Client:	Portland Nurseries
Project:	Portland Nursery, Honley
Our ref:	P1246
Date:	February 2020

This Technical Note will set out the response to the Kirklees Council's (KC) comments on the planning application for the proposed nursery at the Former Eastgate Depot, Honley, Holmfirth, HD9 6PA (ref: 2019/93790). The KC comments are centred upon 2 main issues - parking and visibility; both in terms of vehicles entering the site, and pedestrians crossing the road on Eastgate. This note addresses each issue in turn.

Plan showing highway layout and levels
Scale 1:200

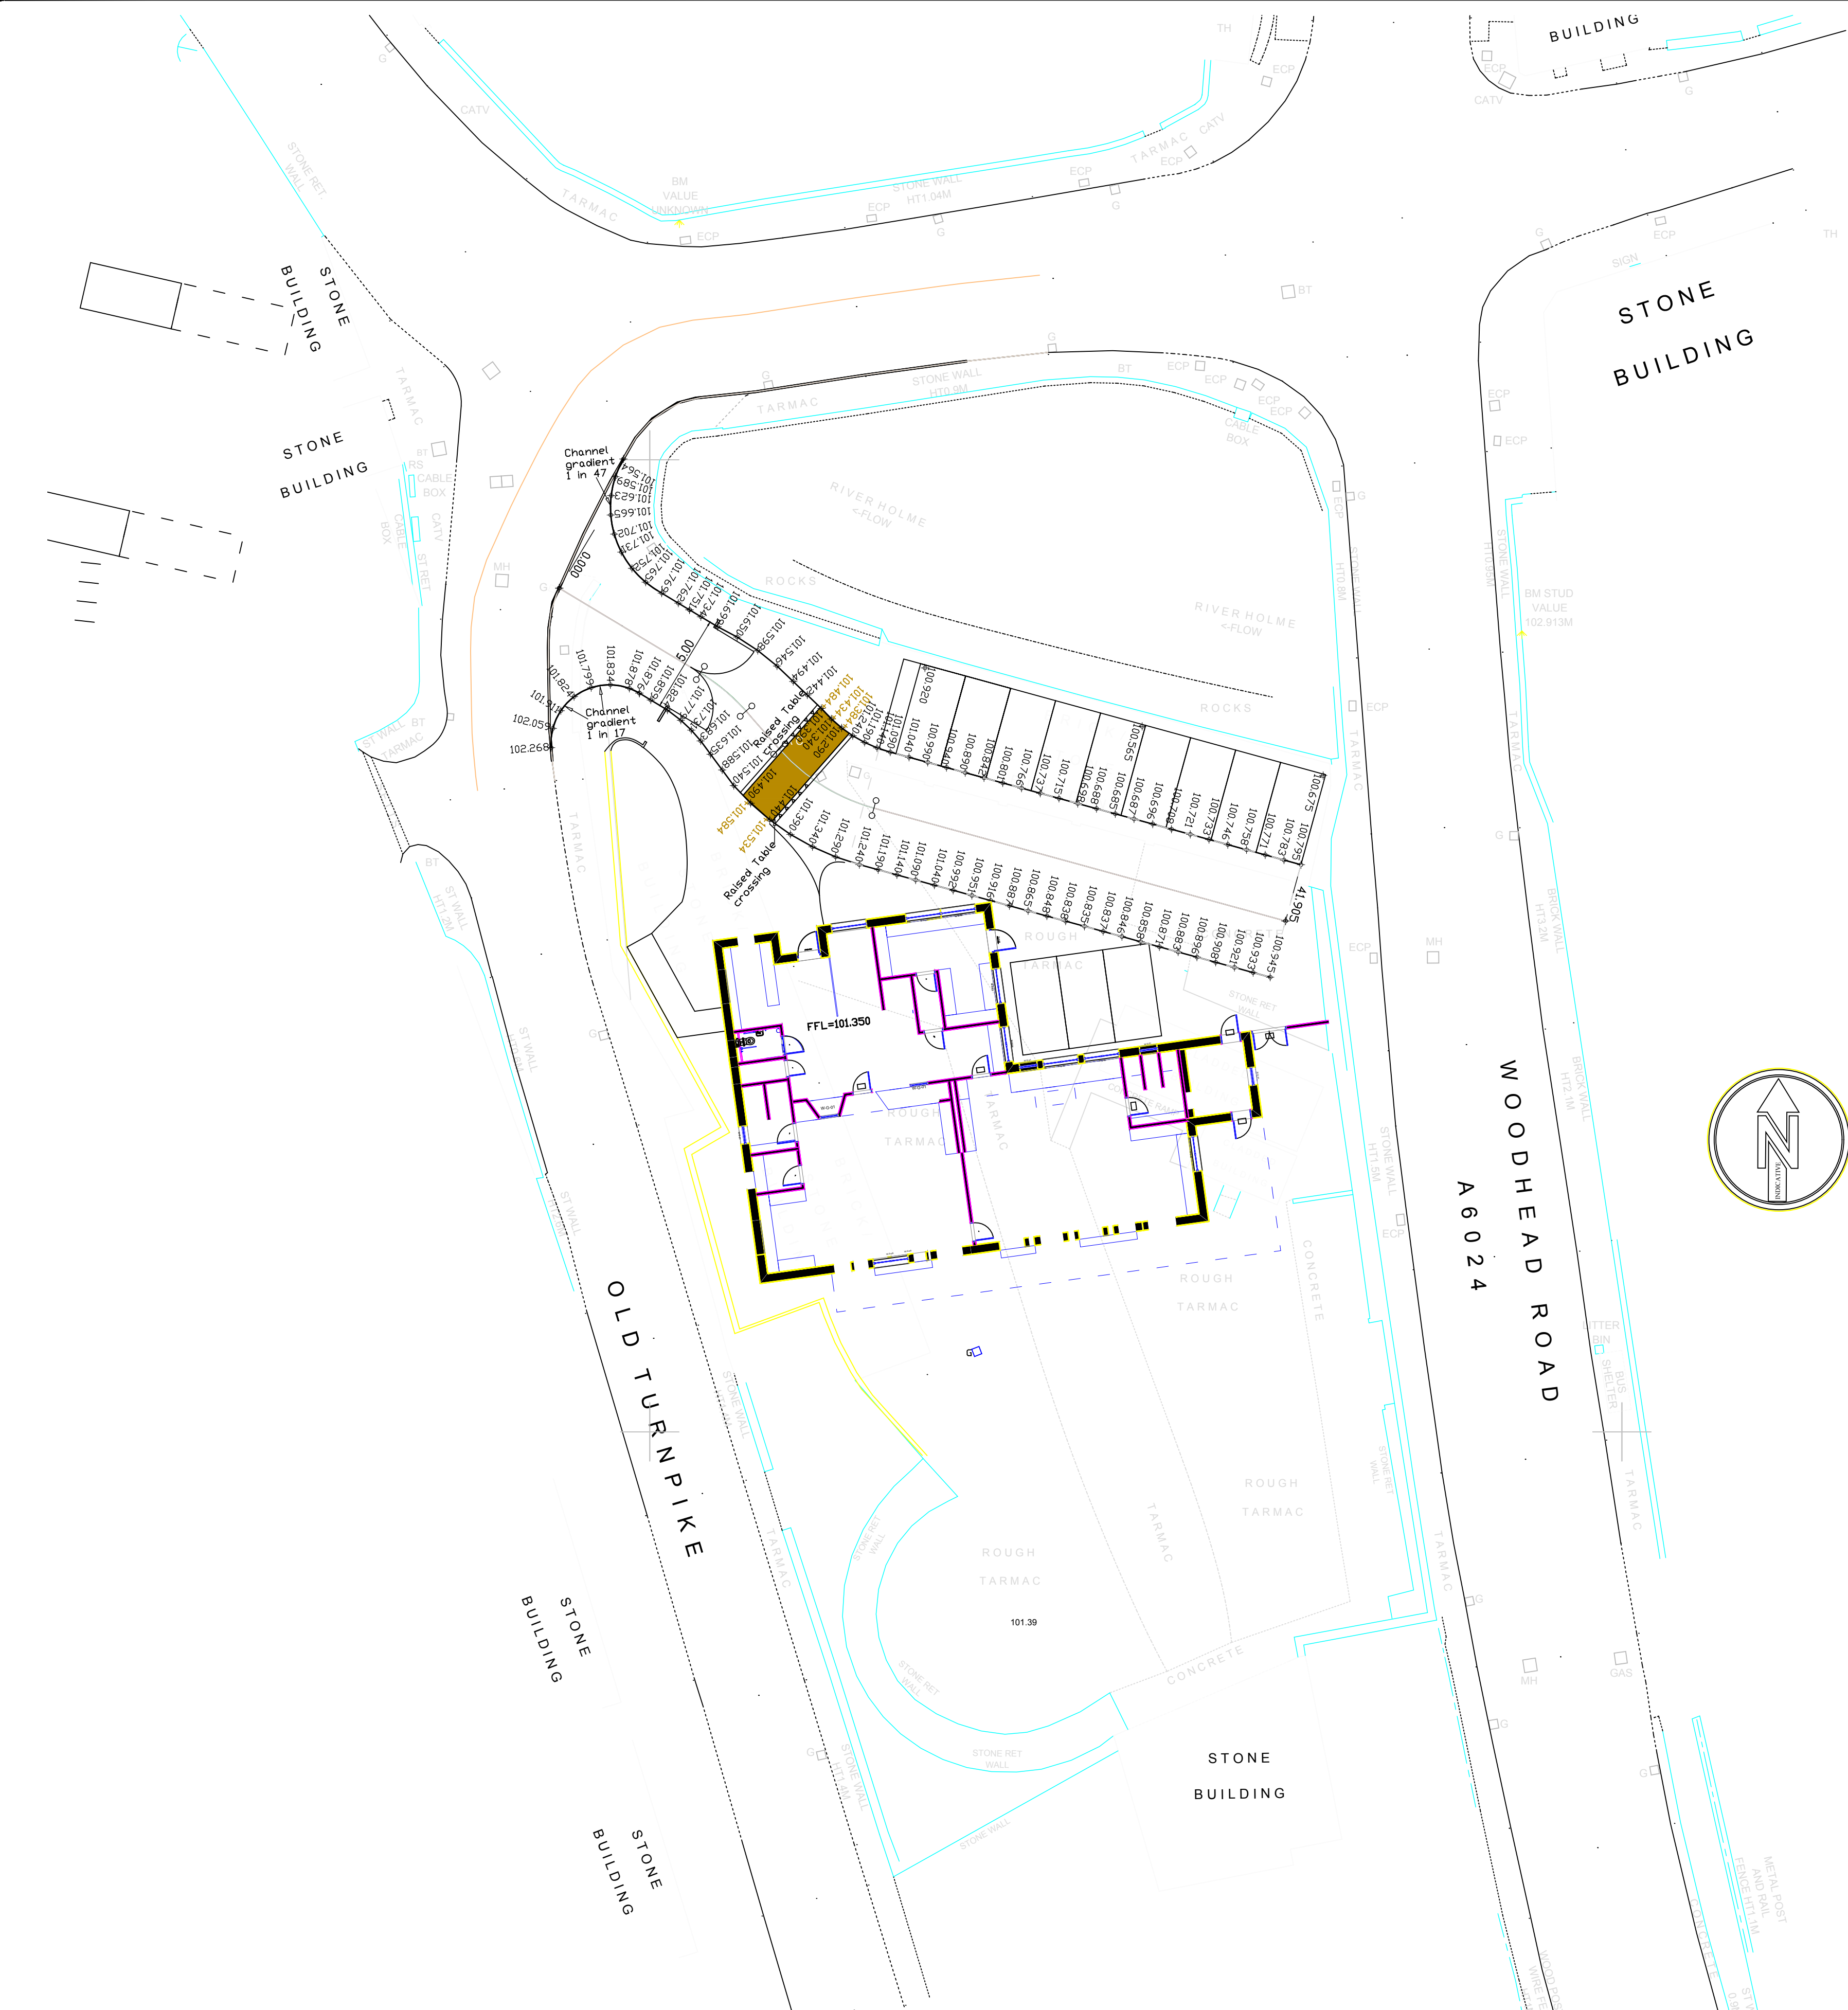
"Although there are no longer prescriptive standards for off-street parking, the previous advice would have required the site to have 7 spaces for staff, and 14 spaces for visitors (one per six children), so the proposed car park falls below this by nine spaces (45%). There is no justification given for this shortfall in the submitted documents".

Even if it is assumed that the duration of stay is a more robust 5 minutes if this quick turnover of parking is applied to the proposed parking provision of 16 spaces (19 spaces minus the assumed 3 for staff), this would equate to a maximum car parking capacity of 192 vehicles per hour. As has been established in the Transport Assessment, the development proposals are anticipated to generate 98 two-way trips in the AM peak hour and 65 two-way trips in the PM peak hour, and, therefore, demand would not exceed the capacity of the car park.

It should also be noted that positive discussions have taken place with a local business. Balooshai Indian restaurant is less than 0.2 miles from our site, as shown in **Figure 1** and have

confirmed they will allow nursery staff to use their car park. The restaurant opens at 5pm and the owners are happy for staff to use their car parking facilities until then. Based on staff rotas for a similar sized nursery at Oakwood House, 10-14 staff who would finish work before 5.00pm and therefore the restaurant car park has enough spaces for staff to park there, if required.

611_P003

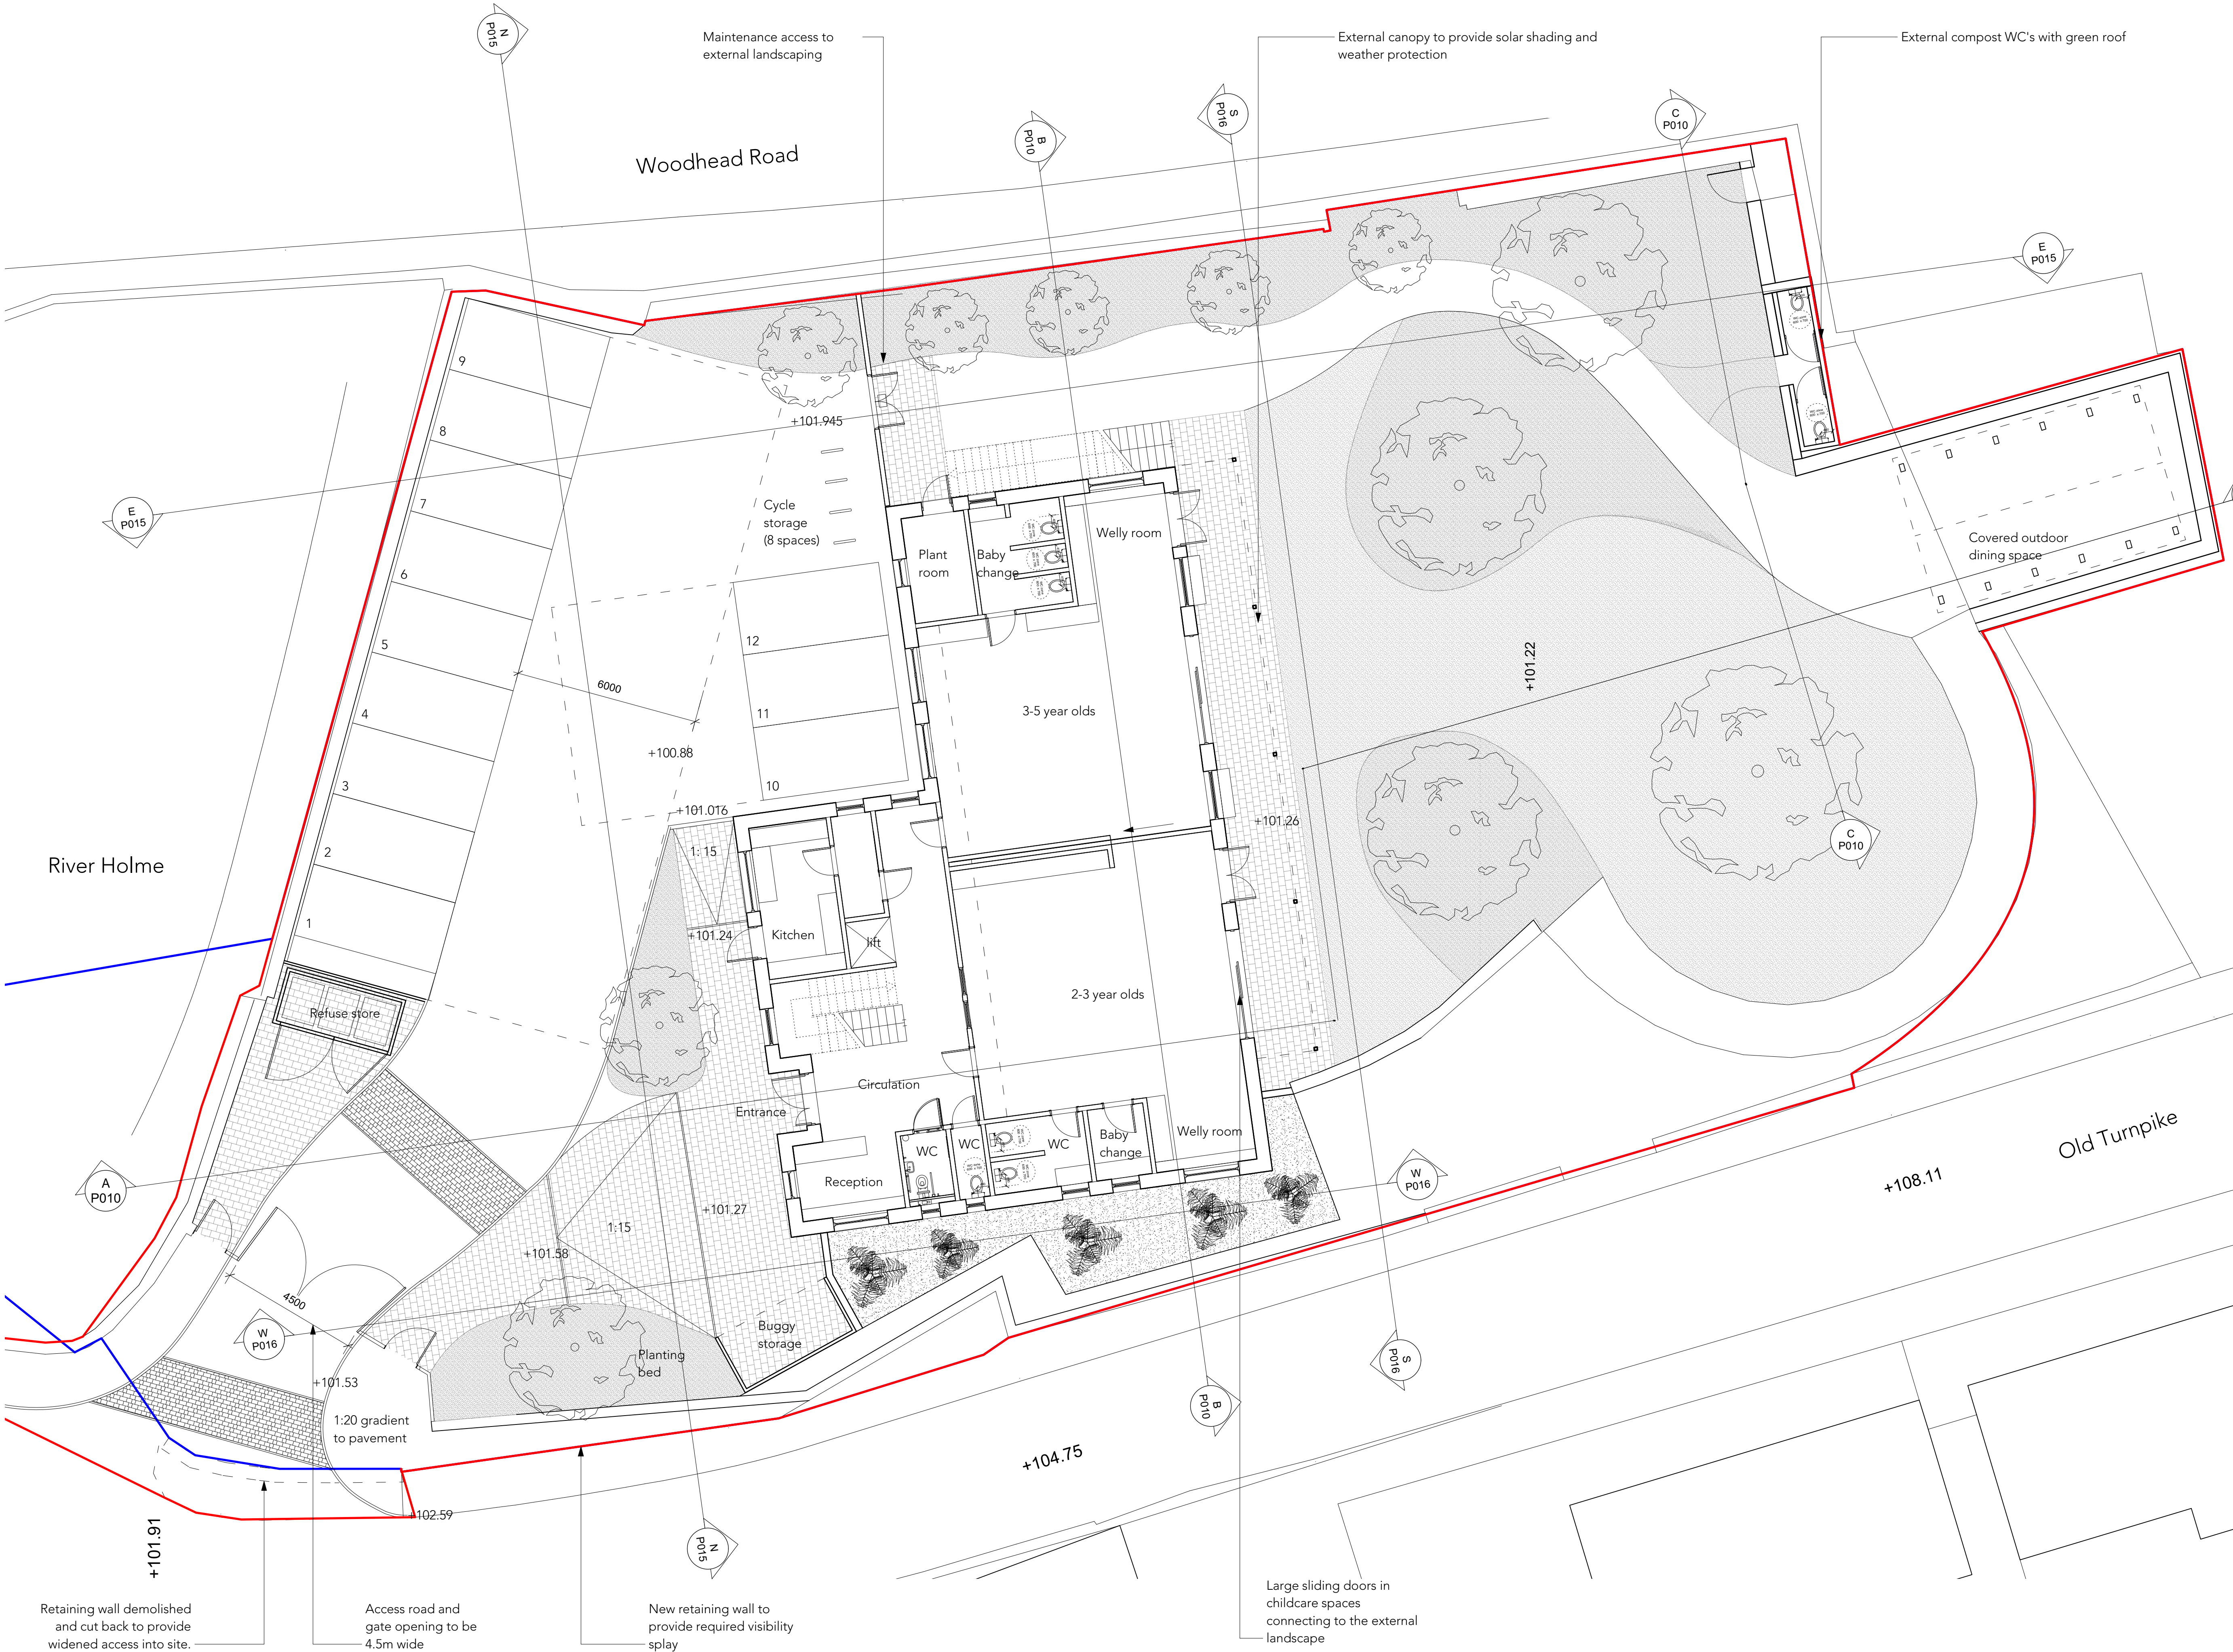
"Presently, the visibility from the site to the left onto Old Turnpike is substandard, and whilst the entrance is to be widened and a new retaining wall constructed to improve this matter, no dimensions of the new visibility splays have been provided".

KC requested Visibility from the crossing point for pedestrians, demonstrated on a plan.

An independent speed survey was conducted using an ATC, on Old Turnpike as it passes the site (Tuesday 7th May 2019). The road is subject to a 30mph speed limit as it passes the site, and as such, visibility of 43m in either direction might be required. Based on the speed survey however, it was demonstrated that visibilities of 26m to the left and 40m to the right along North Eastgate, are appropriate. A Visibility Technical Note can be found in **Appendix A** of this note and contains a drawing showing the visibility splays in accordance with the speed survey.

This can also be found in **Appendix A**. Whilst it is acknowledged that this is not an ideal location, it is limited by the nature of the highway network surrounding the development and represents the best location available.
